Consultation Response from KC, Lead Local Flood Authority
2025/93057 Land off, Hermitage Park, Lepton, Huddersfield, HD8 0JU
Discharge of details reserved by conditions 27 (BEMP) , 28 (swale), 29 (surface water) and 30 (storm modelling, flood routeing) of previous permission 2025/90105 for variation of conditions 6 (PROW), 9 (boundary treatment), 38 (bin collection), 40 (car parking) and 41 (access) of previous outline permission 2022/91735 (with access and layout) for erection of 80 dwellings and associated works
Date Responded: 6th July 2026 Responding Officer: Paul Farndale Responding Ref: 4

Condition 29 Drainage Details.

Condition 30 – Flood Routing

PLOT 7 AND 8 EXCEEDANCE
FLOW ROUTING

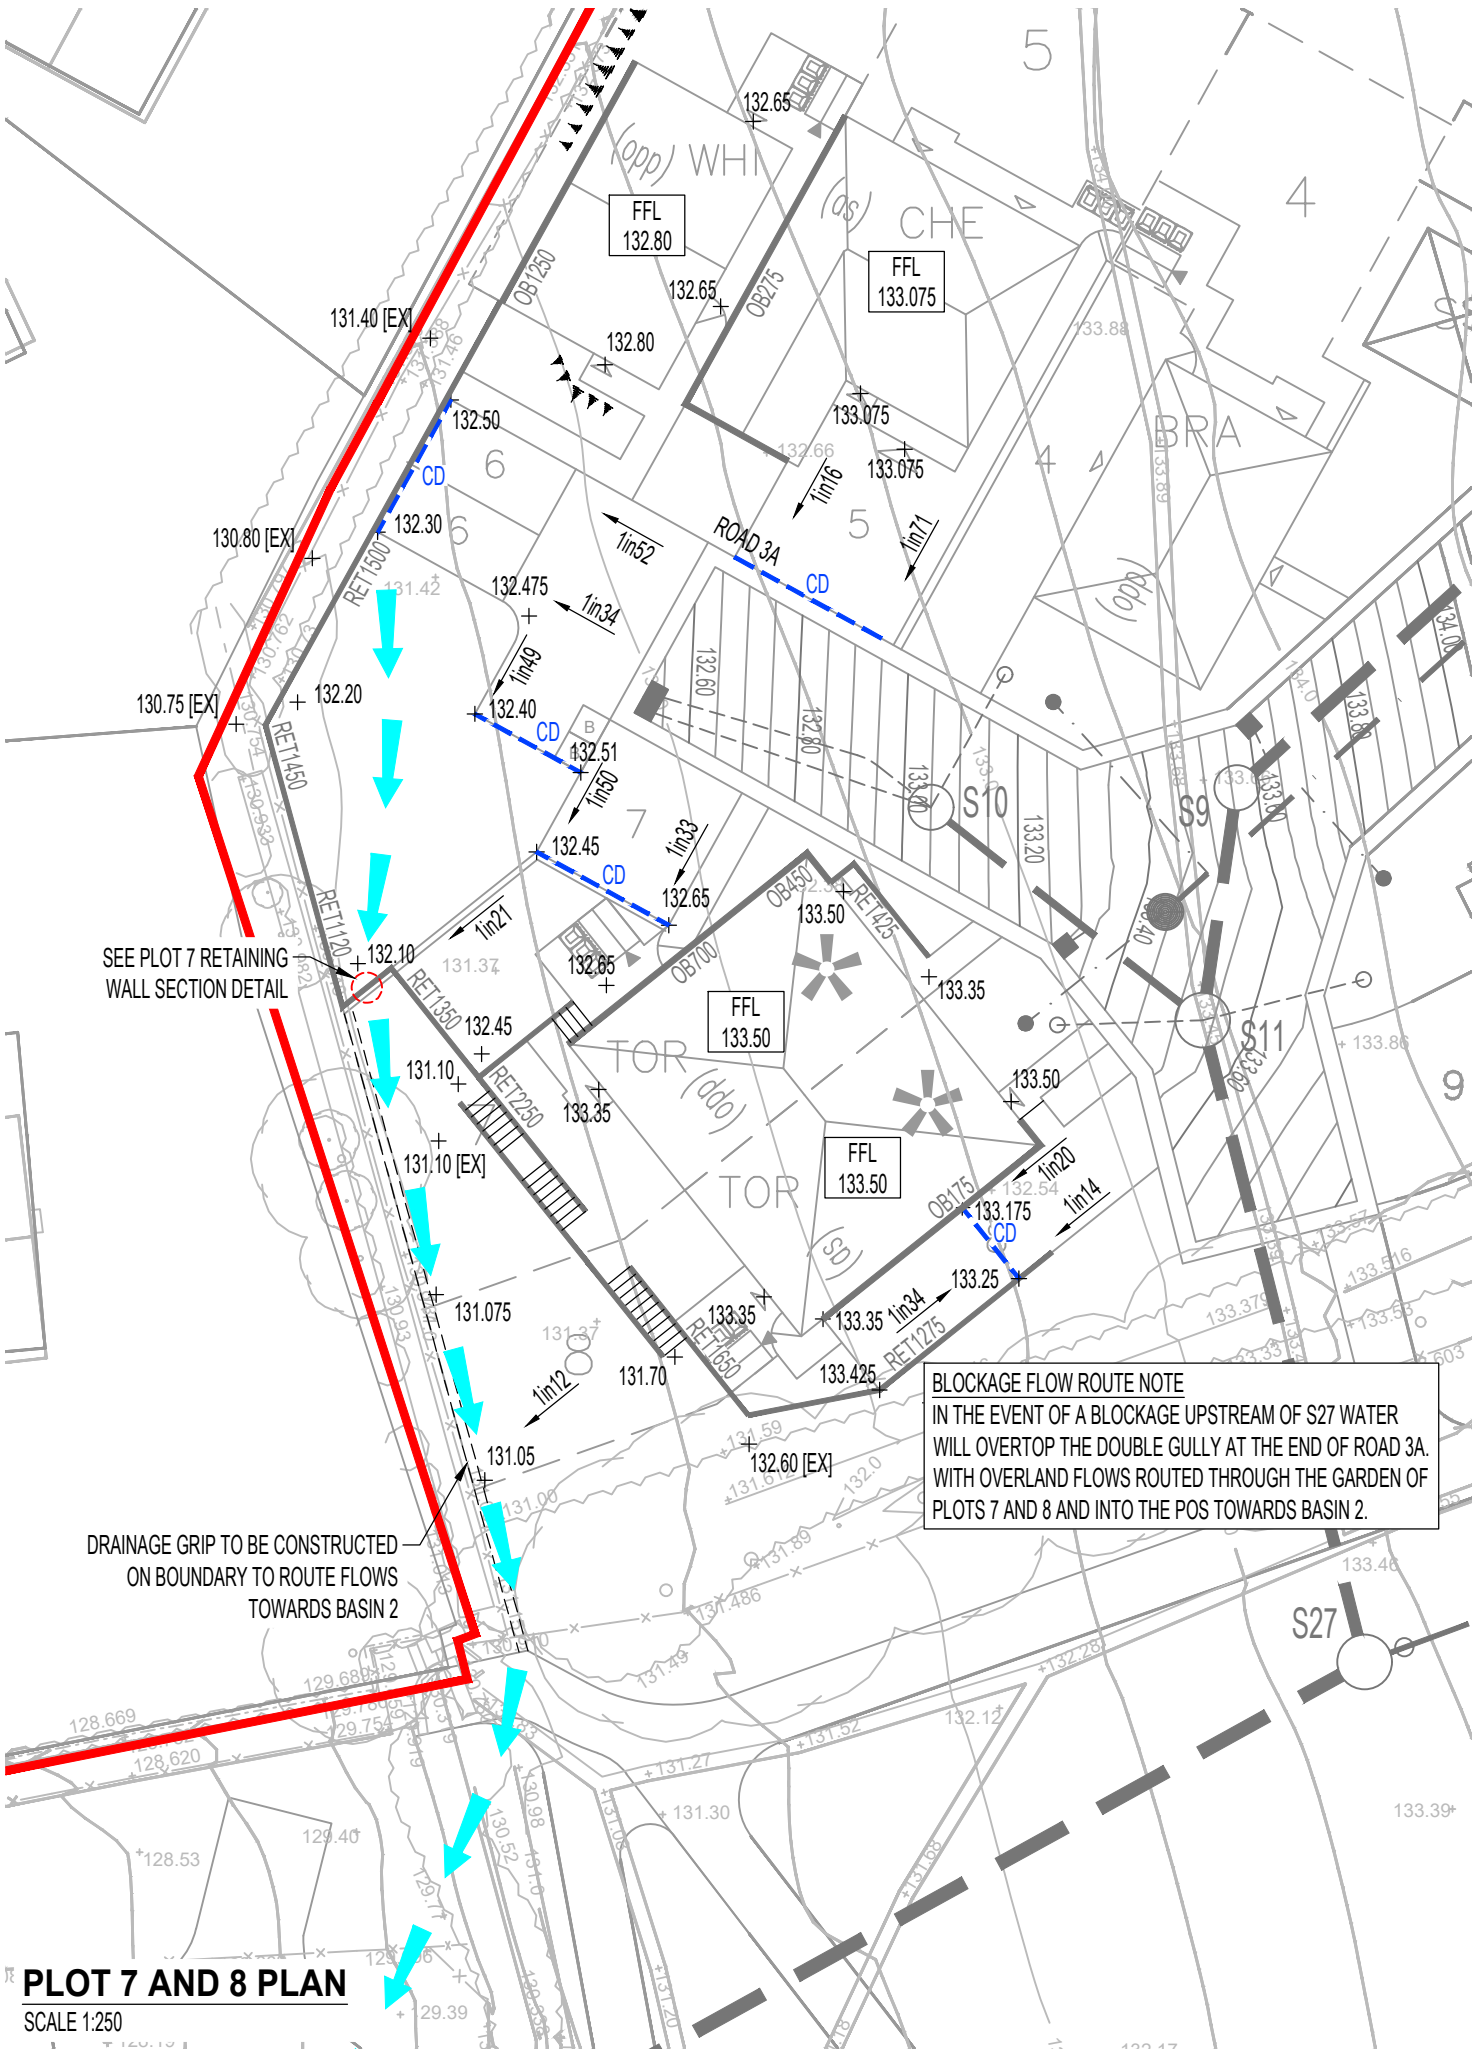
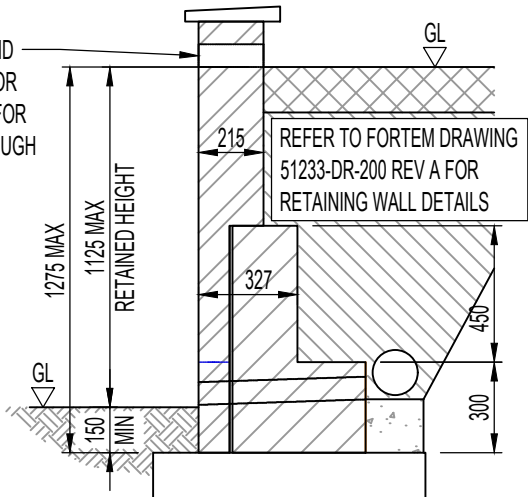
Alterations showing deliberate hole (grip) in a retaining wall at plot 7 to allow flood waters through rear gardens in an extreme weather event when all drainage systems fail, is acceptable.

However, to ensure this is installed, we advise the planning officer to contact the developer and get all other relevant drawings changed. I.e. boundary treatments/engineering layouts etc, and have this 'grip' clearly labelled.

PRIVATE DRAINAGE SHEET

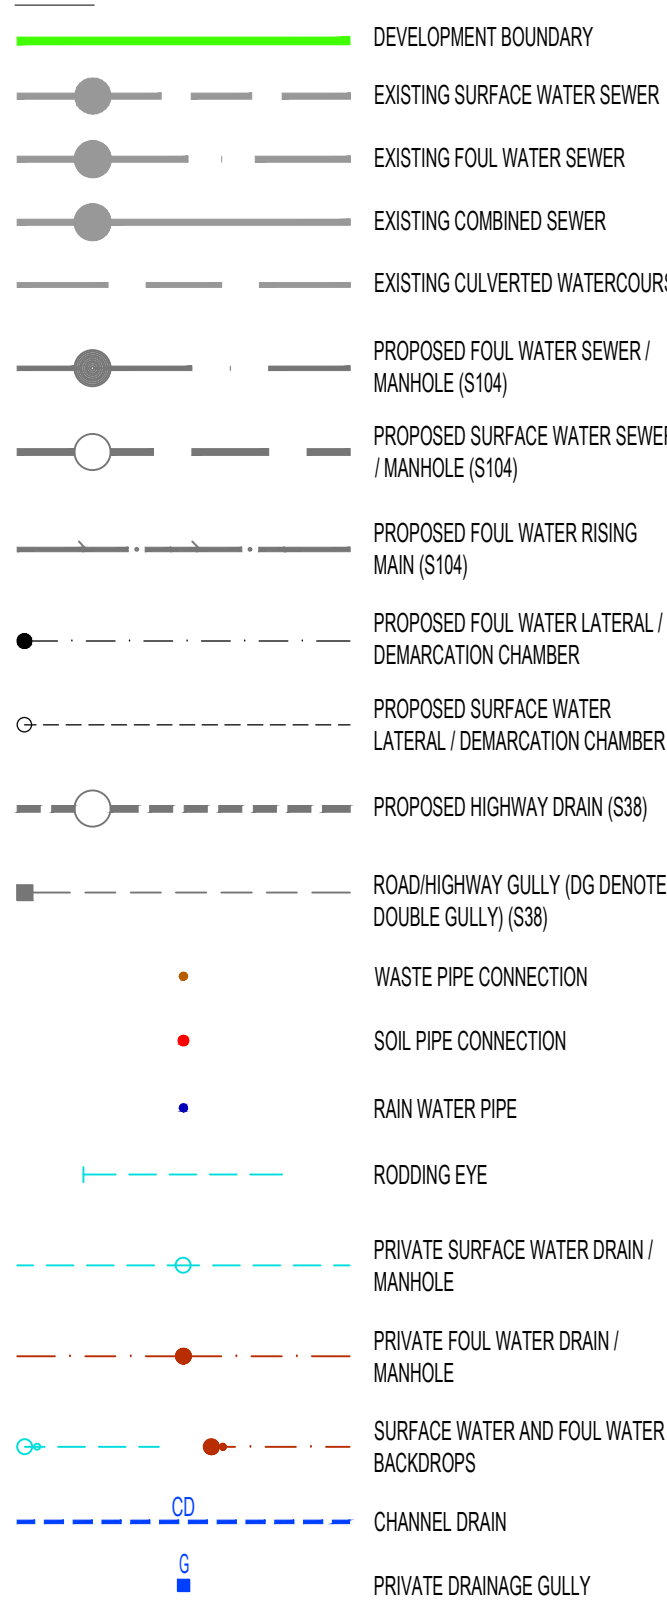
A private drainage plan, if readily available, will assist in discharging this condition. **Done but need engineering drawing showing road contours and levels, including back of footpath. Driveway gradient and fall direction.**

ATTENUATION BASIN DETAILS
BASIN 1

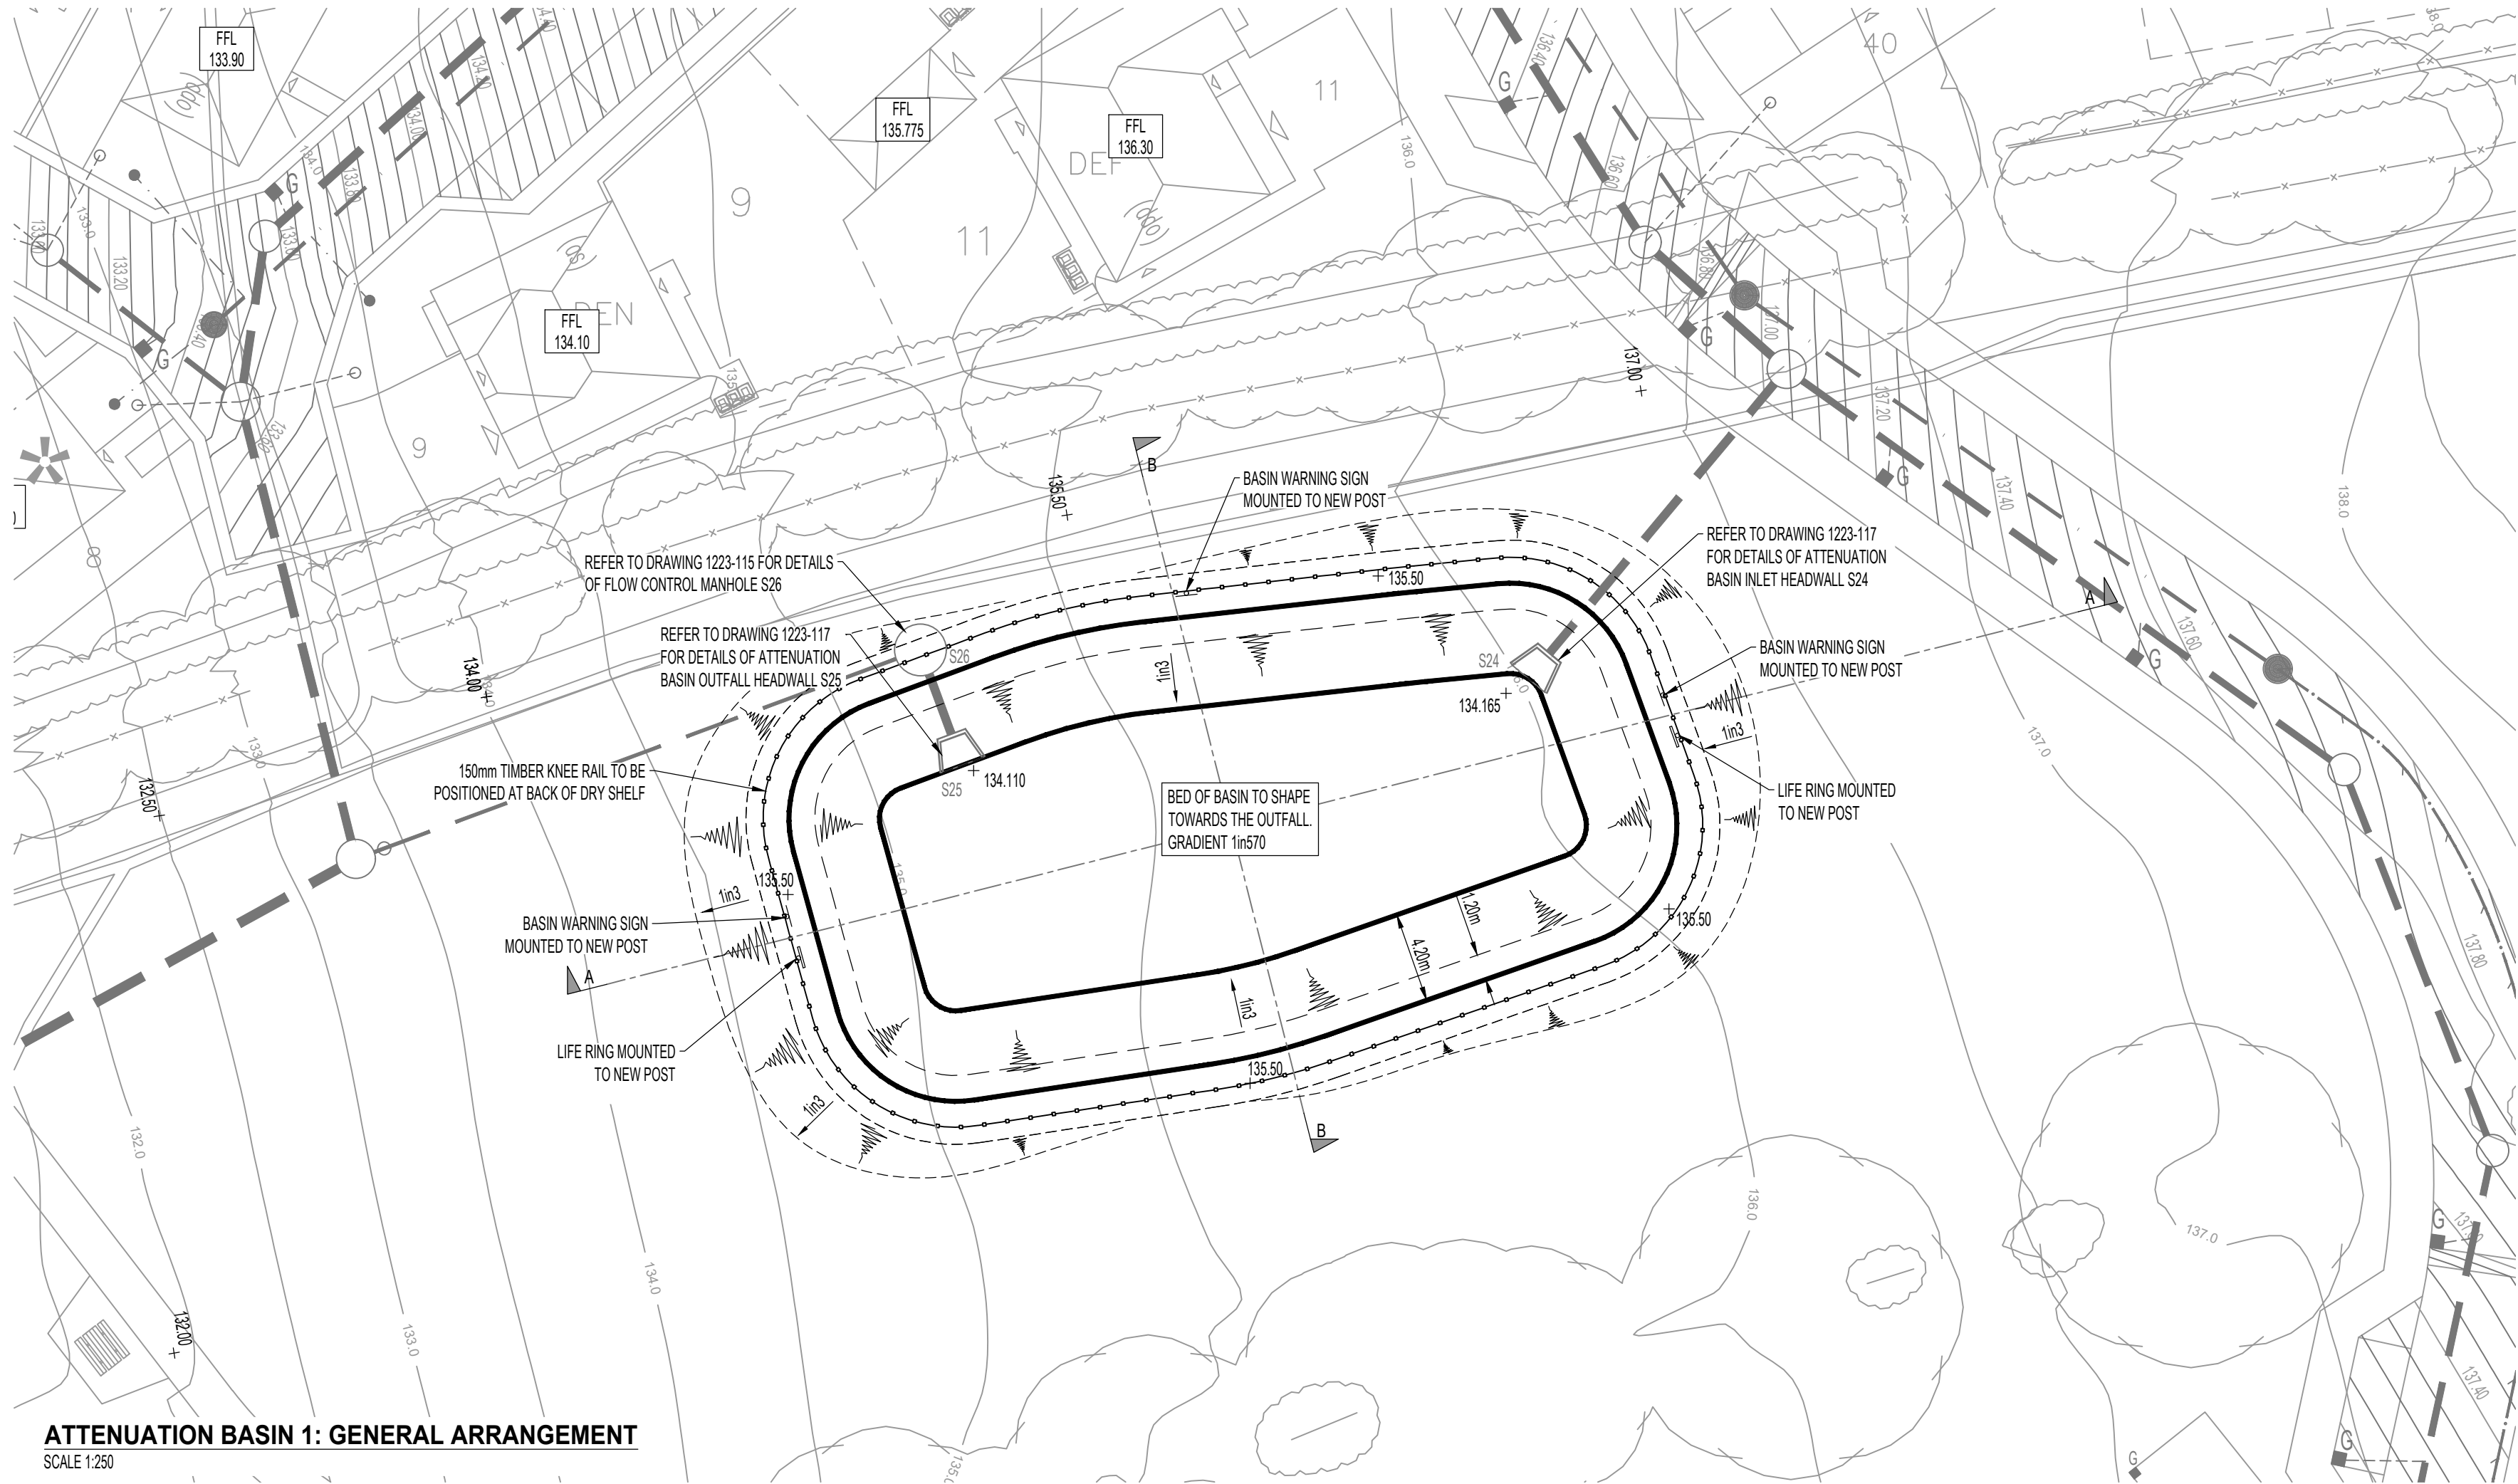
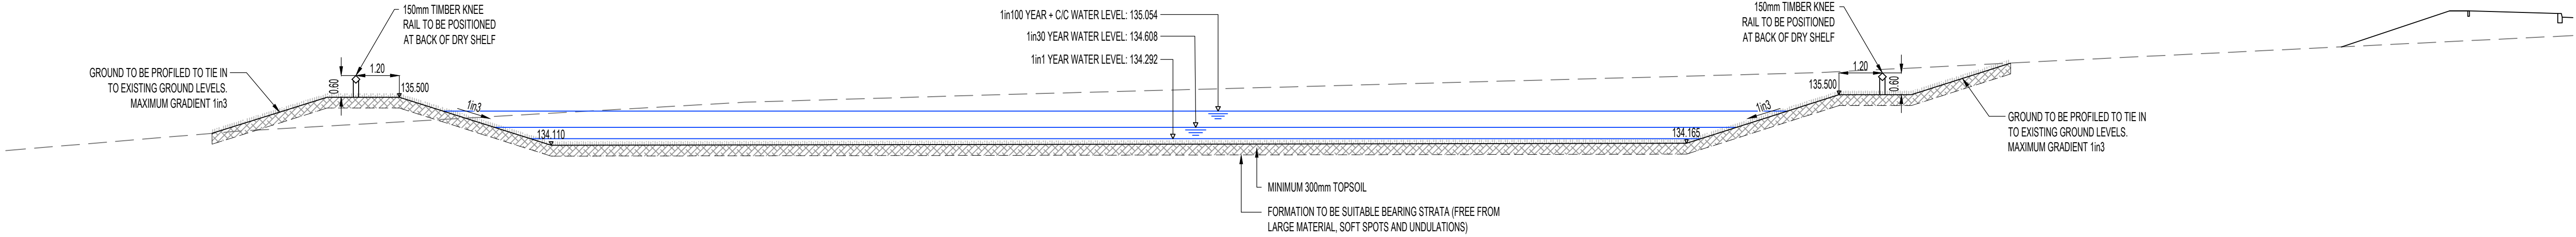
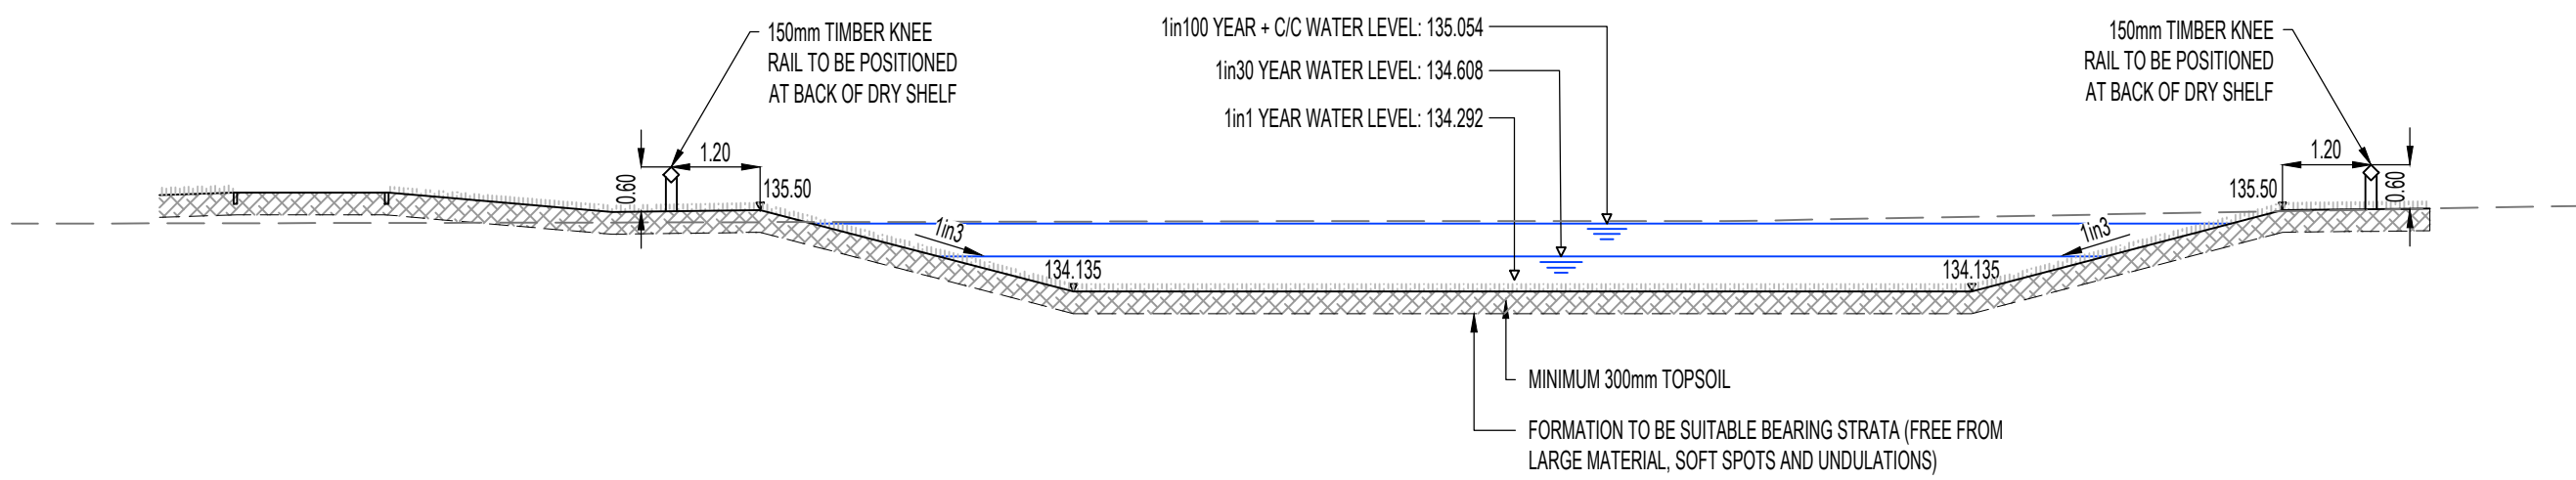
No measurements have been put on the basin drawings. It is appreciated that they are irregular shapes but a maximum width and length for the bottom of the basement and the top (weir point) and any other pertinent measurements are included as previously requested. **Not done.**
